Our Case Number: ABP-313509-22

Re: BusConnects Belfield/Blackrock to City Centre Core Bus Corridor Scheme
Co. Dublin

Application by NTA Under SID for Bus Connects Blackrock/Belfield Core Bus Corridor
Case Ref: HA29N.313509

Applicant Name: Dr. Mike McKillen

**TYPICAL SECTION V-V**  
**NUTLEY LANE**  
 LOCATED ON GA SHEET 22  
 DRAWING REF: BCIDC-ARP-GEO\_GA-1415\_XX\_01-DR-CR-0022

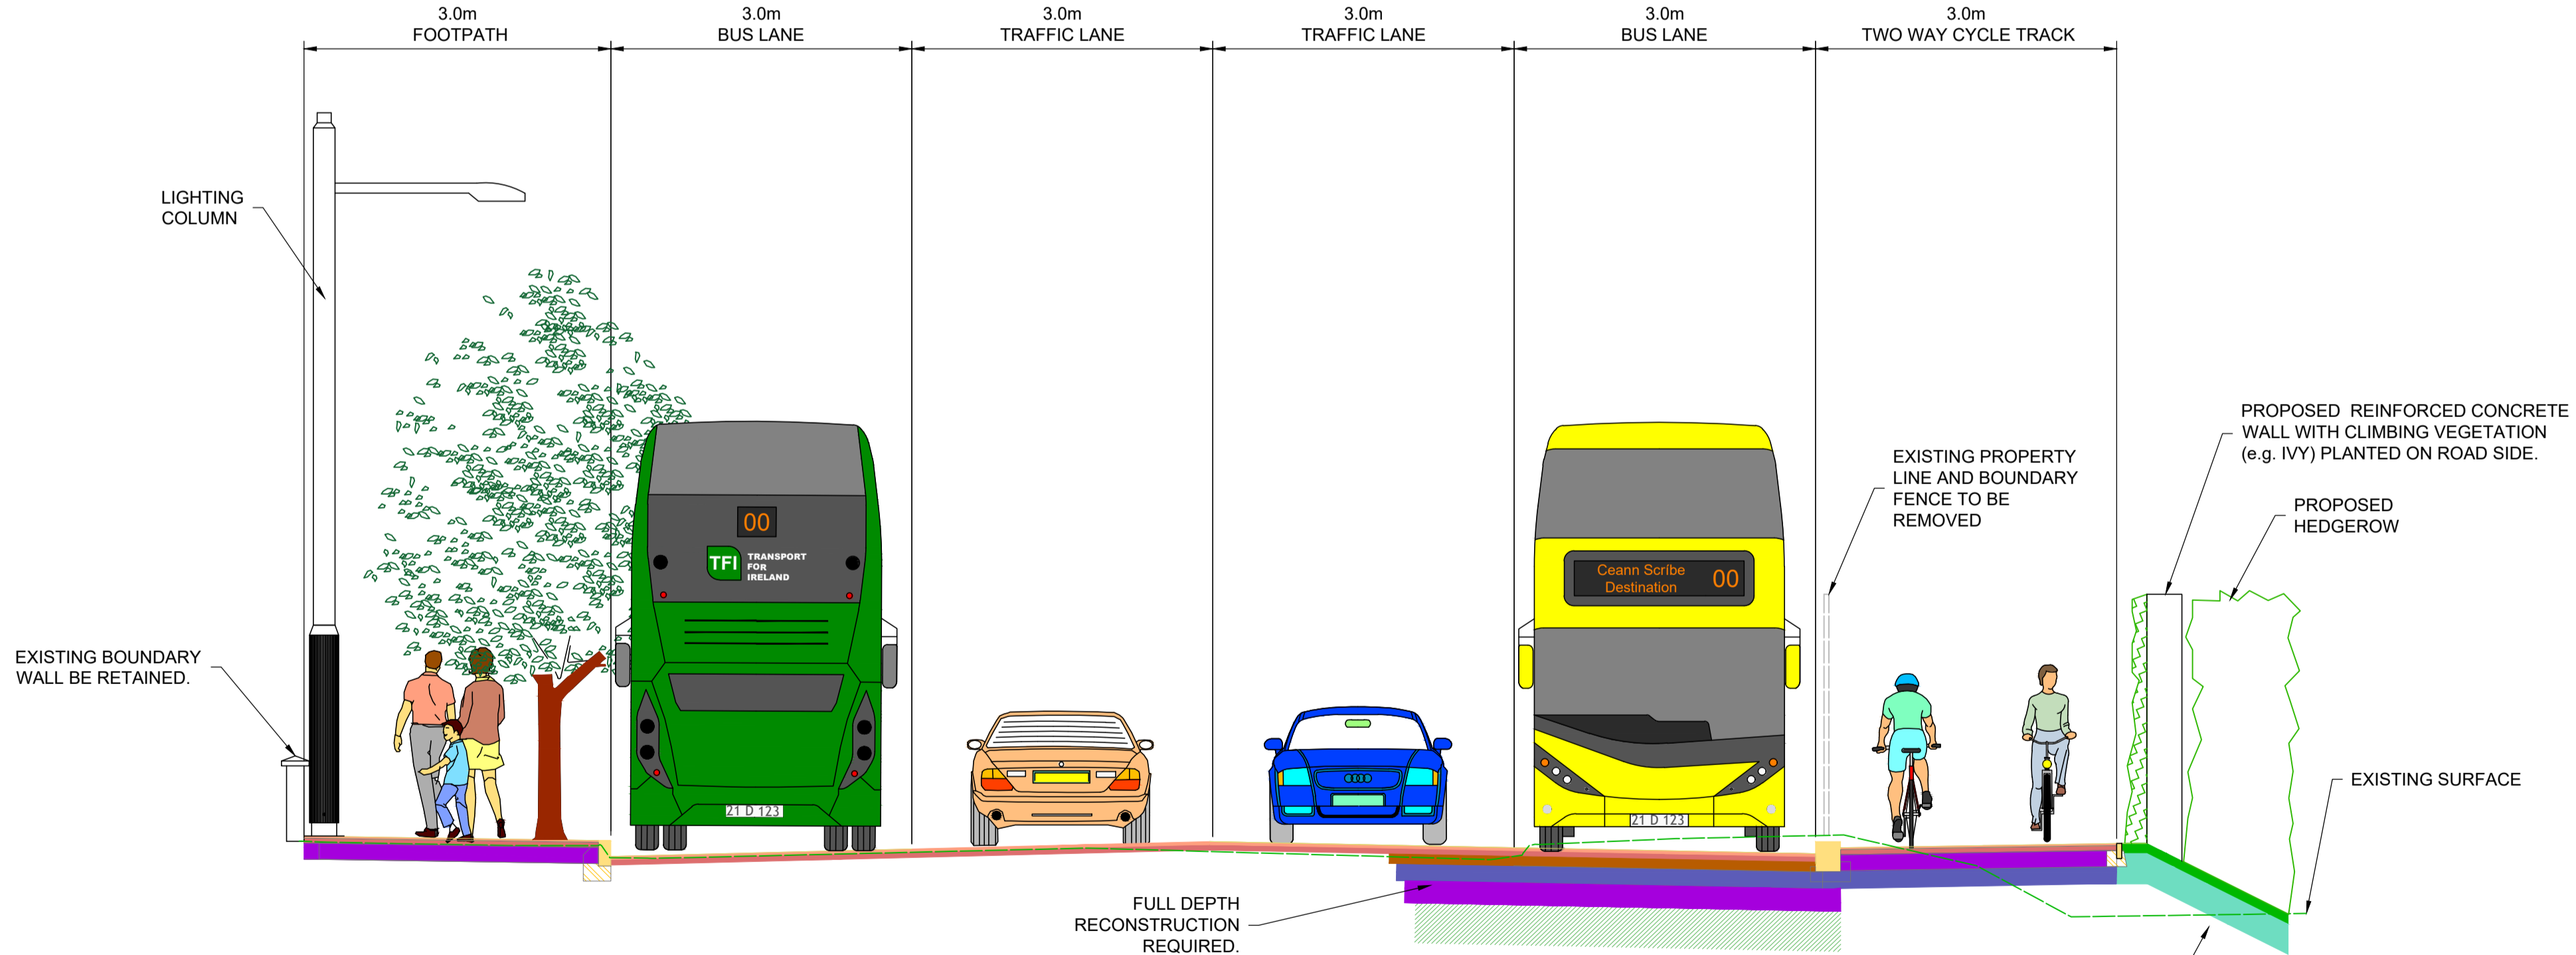
Consideration must be given to a redesign of this overly complicated Nutley Lane proposed layout. A conventional one-way cycle track (2m) either side of the full length of Nutley Lane. This route is a main accessway to UCD so a 3.0 m two-way track as proposed is inadequate. Stopping the eastbound two-way bike lane entirely at the entrance to Vincent's Hospital provides far too low a quality of service for this very busy route. An Bord should request that the applicant consider making Nutley Lane one-way for motor traffic, so there's less land take and more modal shift is encouraged.
